CITY OF PORTLAND, MAINE

February 3rd, 2014

Project Name: "118 on Munjoy Hill" Condominium
12 unit residential, and 2 unit commercial, condominium
Project ID: #2013-255
Project Address: 118 Congress Street
CBL: 16-D-2
Applicant: Ed Theriault, EMT, LLC (118 Condominiums, LLC)
Planner: Jean Fraser

On January 28th, 2014 the Portland Planning Board considered and approved a Level III Final Site Plan and Subdivision proposal for the construction of a 4-story 14 unit condominium building at 118 Congress Street, comprising 2 commercial units totaling approximately 1800sq ft floor area, 18 parking spaces on the ground floor to the rear of the commercial units, and 12 residential units above.

LANDSCAPE PLAN
SCALE: 1" = 8'-0"

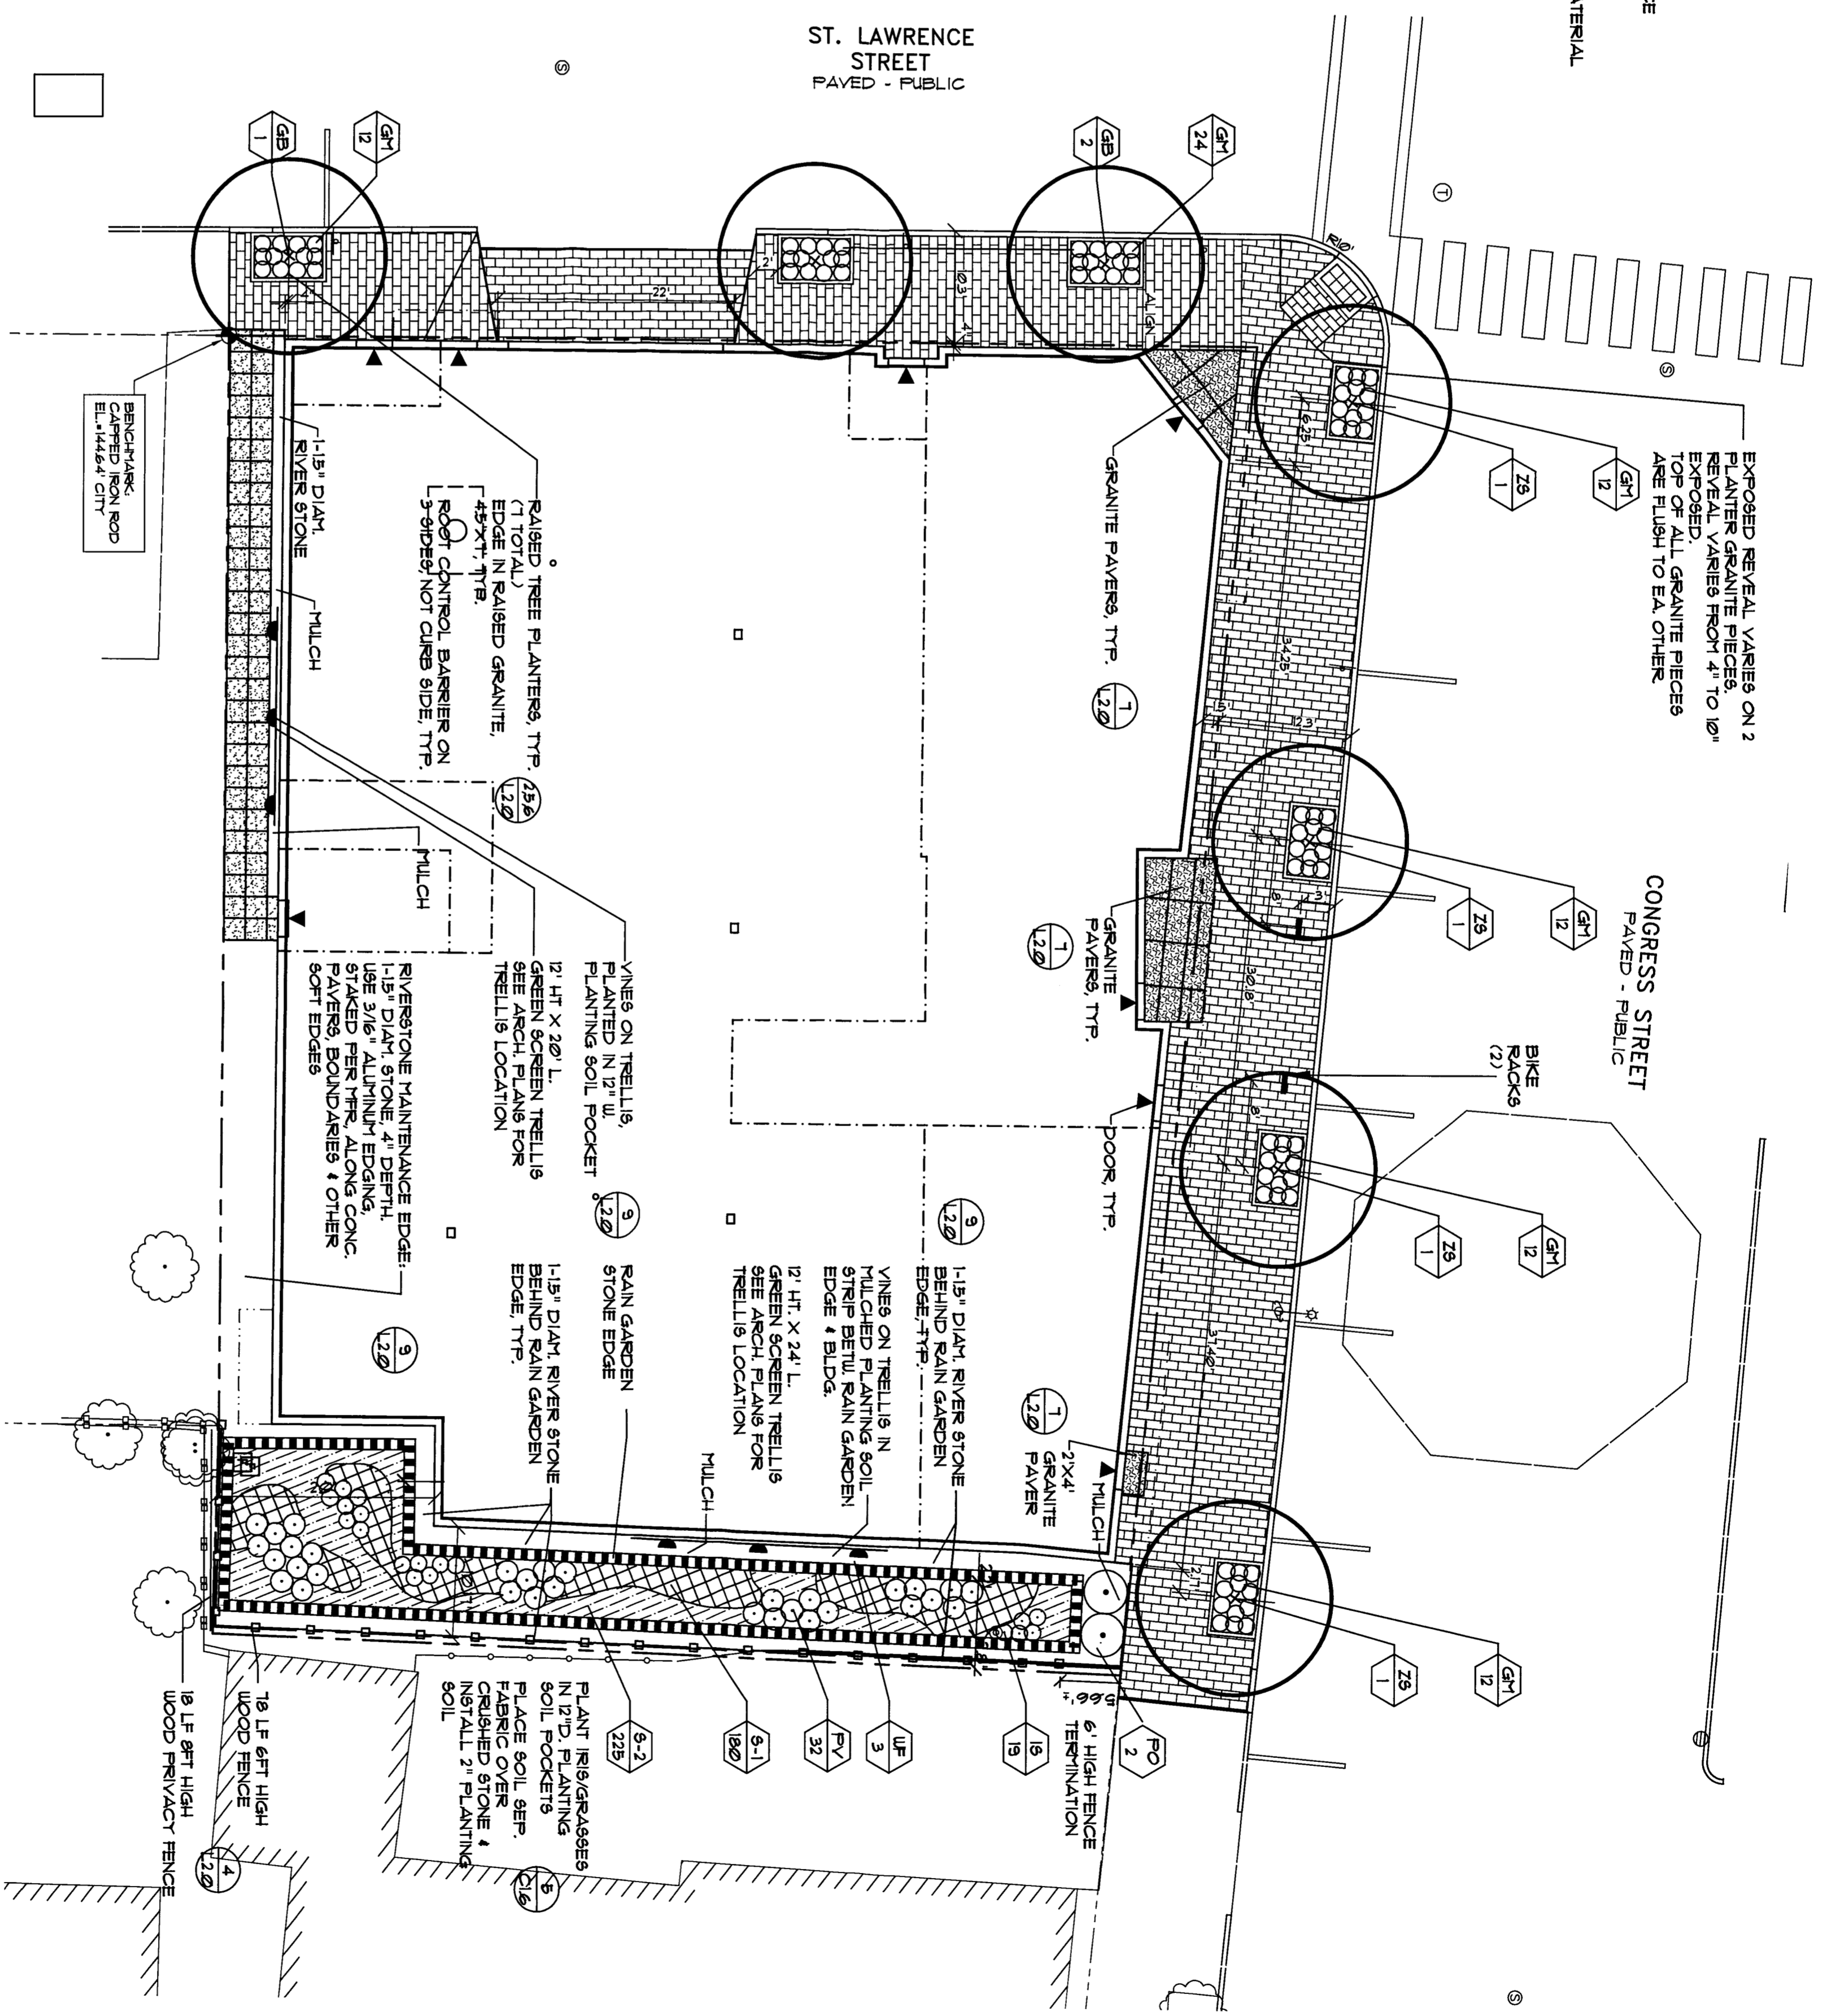
a) Street-trees - the project proposes to plant (6) street trees, (4) along Congress Street, 'save' the existing Pin Oak and plant (2) new on Saint Lawrence Street. Updated plan shows the trees planted in raised granite tree wells with herbaceous planting. If on-street parking is proposed, the tree spacing or setback away from the curb to prevent the opening of car doors is important. The trees can be placed to match the in-between on-street parking, making sure there is good access to the sidewalk from parked cars. The residential tree standard of one tree per unit would also be a condition. Building overhangs over the public way should be discouraged to allow the street tree growth.

'Tree Save' - I was hoping the project could protect or save the large Pin Oak on Saint Lawrence Street, while the recent plan does show this, a recent site visit confirmed the crown of the tree would be severely impacted or one-sided, thus reluctantly yield to the fate of removal due to proposed building location. An additional street tree would be requested. Also, the proposed new tree on Congress Street near the corner of Saint Lawrence should be shifted slightly away from the intersection perhaps 2 - 3'. The recently planted American Elm along Congress Street should be saved and replanted by the city.

Tree types - It would be ideal if the tree types along Congress Street are all the same species. I would recommend the Columnar 'Musashino' Zelkova to be ideal due to the narrow space. See <http://www.jfschmidt.com/articles/musashino> and photo below.

The 'Red Sunset' Maple crown shape is too broad for this space. Along Saint Lawrence Street again a more narrow tree is needed, it could be Ginkgo 'Magyar' or 'Autumn Gold' cultivar (seedless), due to narrow sidewalk space. (photo 'Musashino' Zelkova, narrow vase shape crown)

b) Landscape - The recent revision adds herbaceous planting to the tree planters and the 'backyard' / rain-garden edge. Additional screening to the adjacent property should be considered, this might be achieved by adding higher branching landscape planting or higher fencing (5'). The rain-garden planting with mostly herbaceous plant material will reach a low height. It does not appear to meet the B-1 Zone landscape standard (i) " A densely planted buffer and / or fencing will be required to protect neighboring properties..." Suggestions could including some taller shrub plants along with a higher wooden fence. The Green Wall proposed will also help screen the building. Additional green-wall / landscape planting could be used on the West elevation to the left of the garage door, this area seems blank; and to the left of the center door on Congress Street away from the overhead canopy.

Granite planters in right of way - the six granite planters are proposed to be planted with street-trees and 'Cranesbill', perennial geranium. This will add interest to the typical mulched tree well. Long term however it is unlikely the city would be able to maintain these plantings. Ideally, the project could adopt the tree wells and maintain the landscape planting.

- v. That the applicant shall submit revised plans and associated documentation, for review and approval by the Planning Authority and City Arborist prior to the issuance of a building permit, to address the comments by the City Arborist, Jeff Tarling, dated 1.22.2014 regarding the street tree location, species and long term maintenance of the other plantings in the ROW; and

- vi. That the applicant shall submit a revised Landscape Improvement Plan to address the City Arborist comments of 1.22.2014 in respect of the site landscape (buffering and additional trellis), to also address CPTED principles as relevant, for review and approval by the Planning Authority and City Arborist prior to the issuance of a building permit; and

1 NORTH ELEVATION
1/8" = 1'-0"

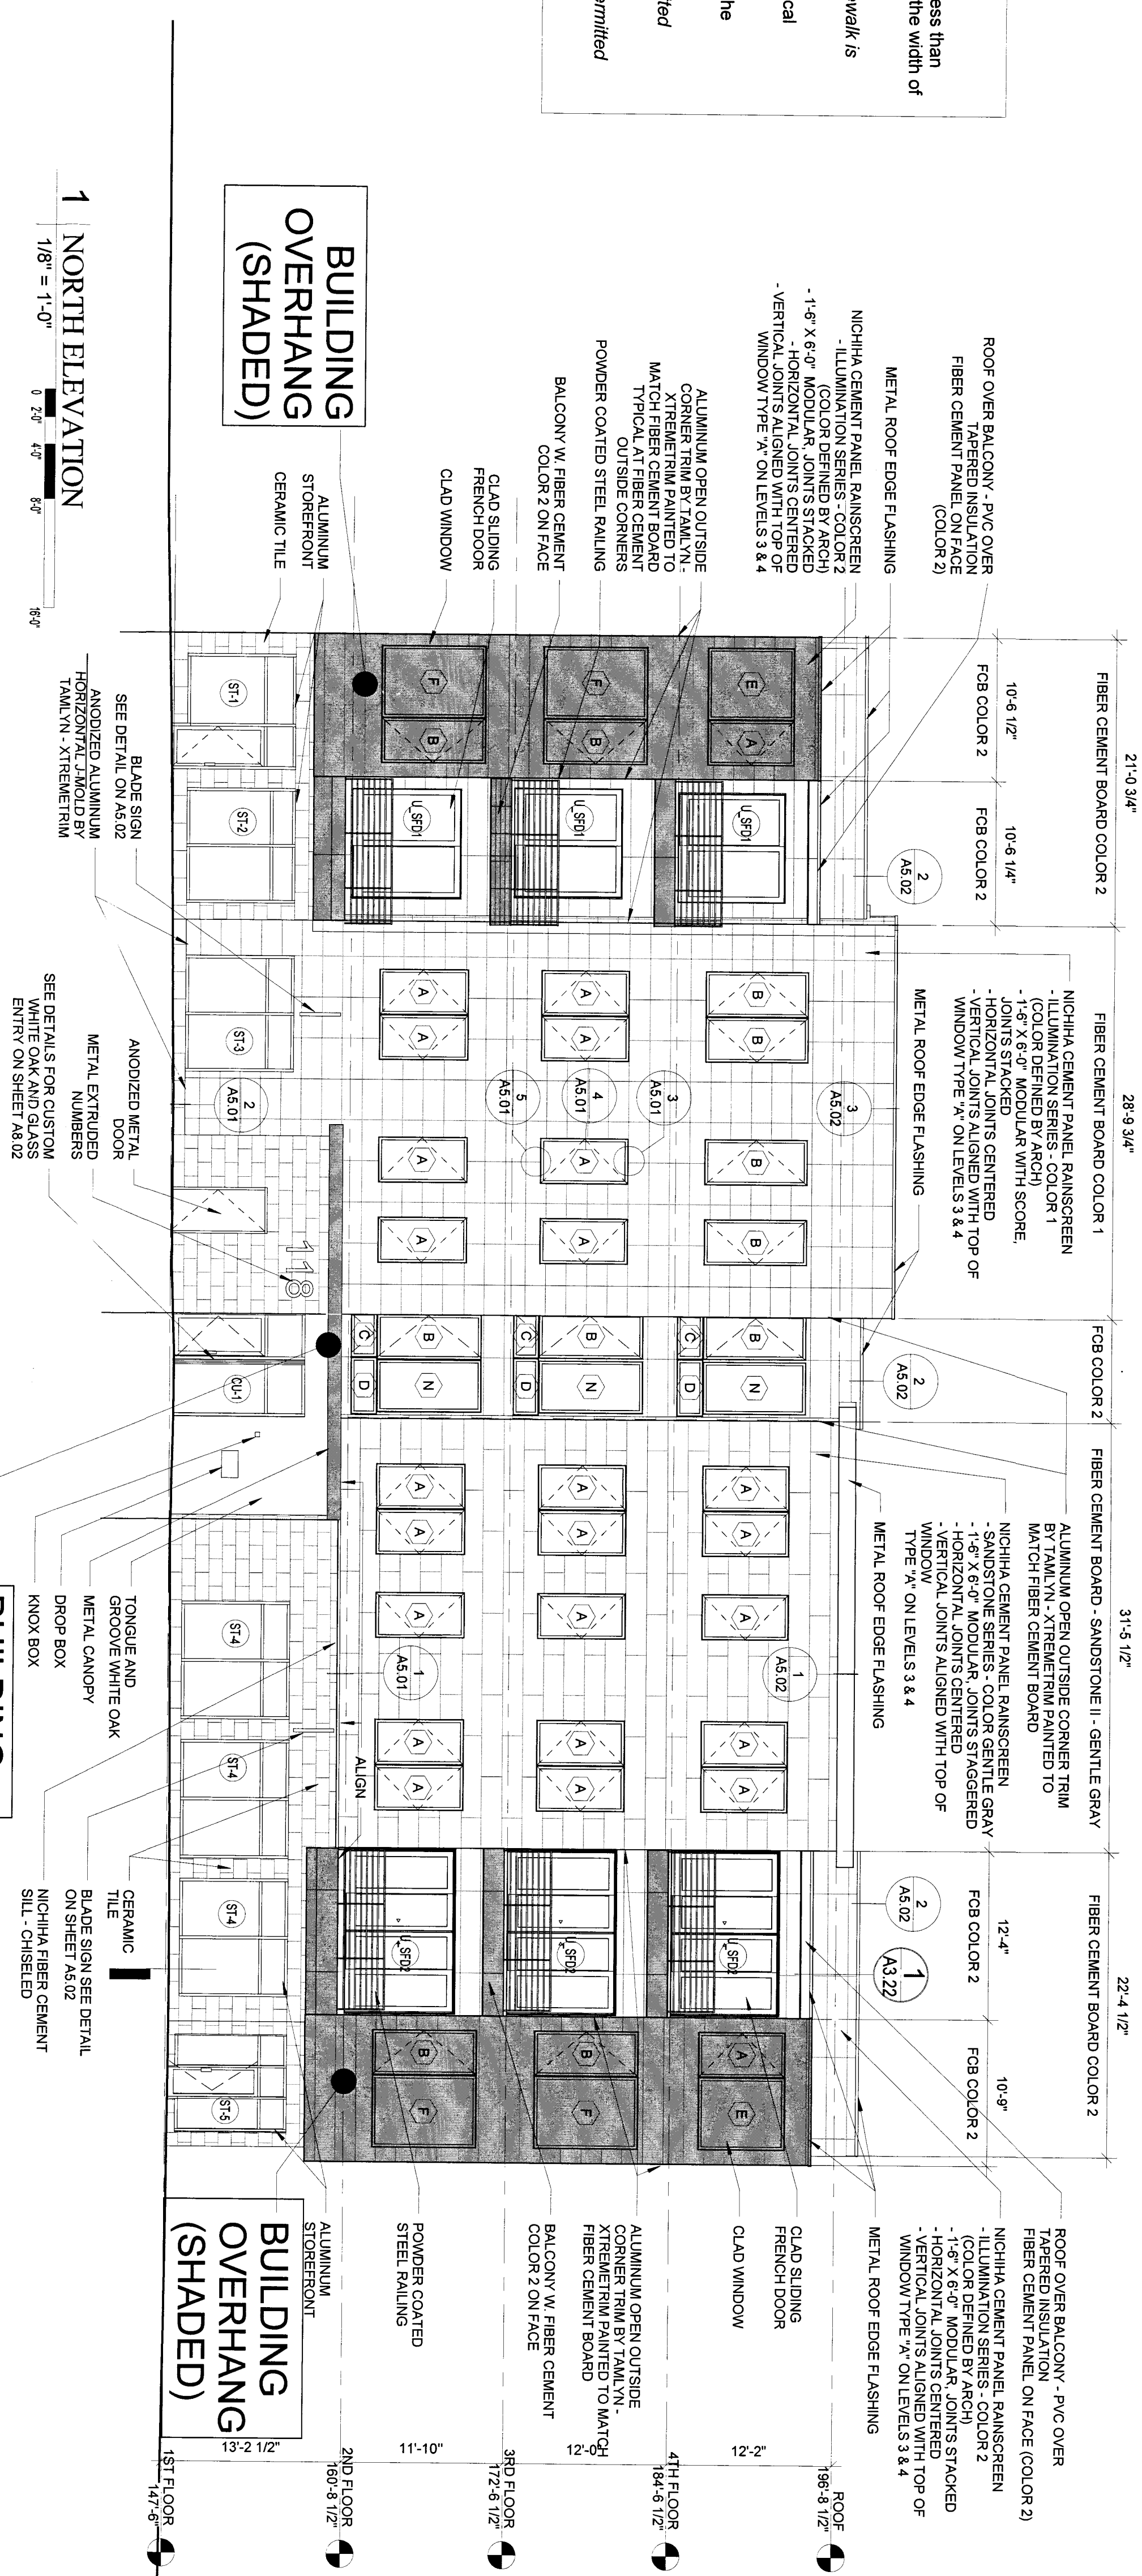
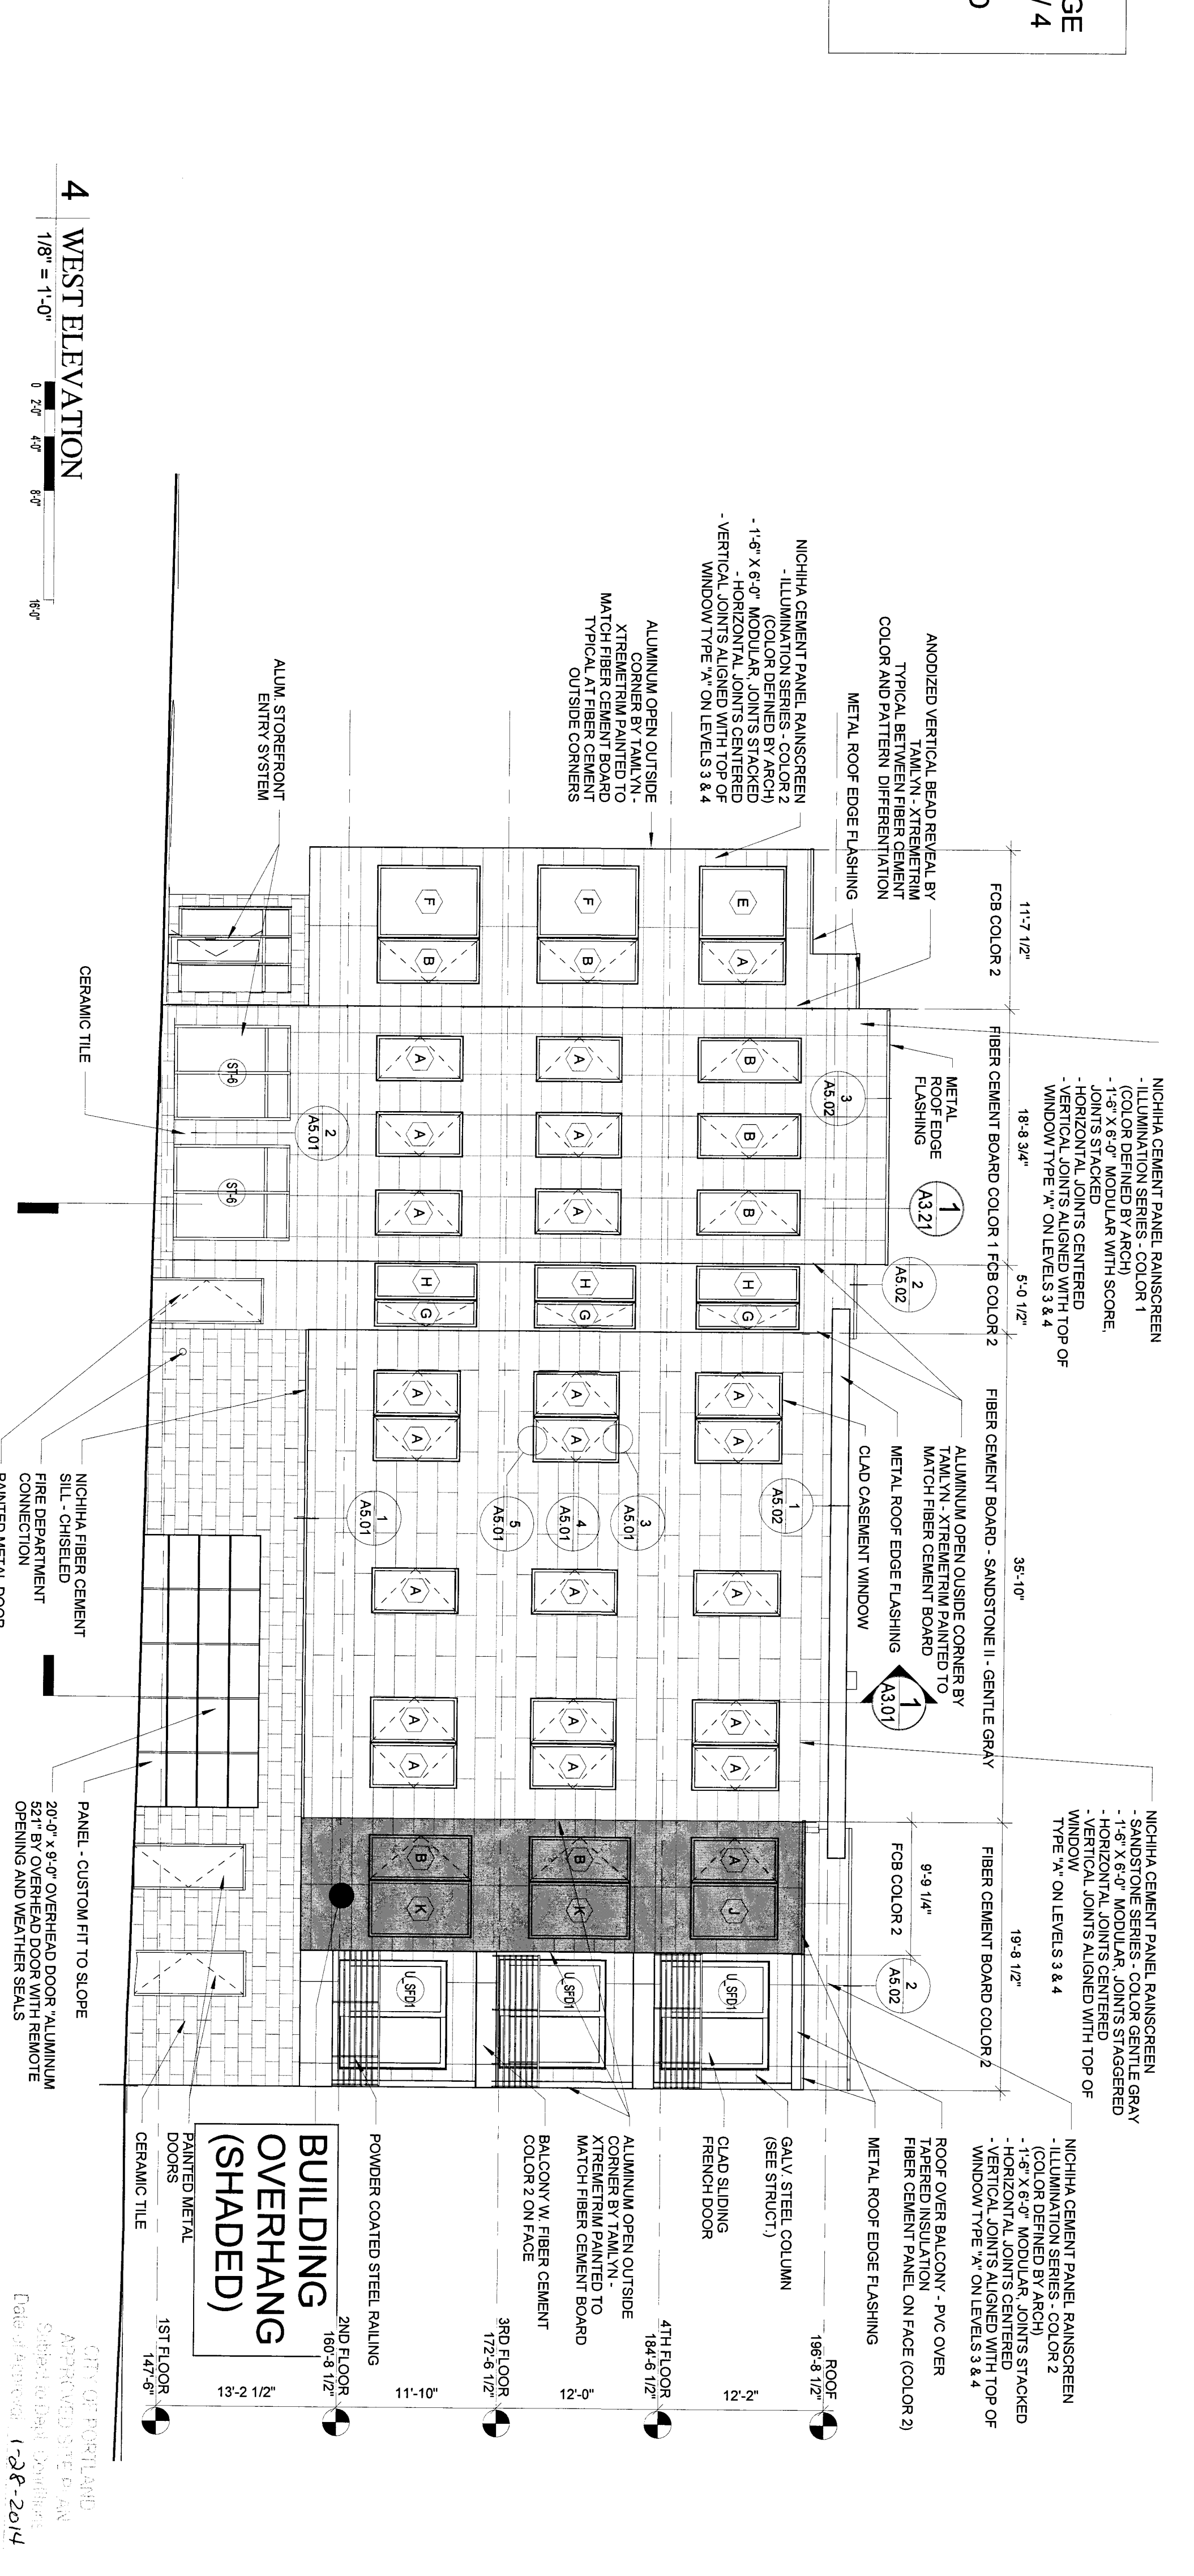
- i. The applicant shall submit a revised building design that results in the decks on St Lawrence Street being within the property boundaries while maintaining the current quality of design in regards to facade articulation and variation of form, for review and approval by the Planning Authority prior to signing of the Subdivision Plat; and

The Planning Board, in considering this project, were aware that the associated building projections (including decks) over the ROW would need a license to be approved by the City Council and that there were staff concerns about this aspect of the project. The Planning Board voted 5-2 (Dean and Hall opposed) to send a Communication to the City Council outlining the basis of the Board's support for the projections on this particular project.

- ii. That the applicant shall obtain a license from the City Council, subject to review and approval by the Corporation Counsel's office, for any building features associated with the approved design that extend over the City right-of-way, prior to the release of the signed Subdivision Plat; and
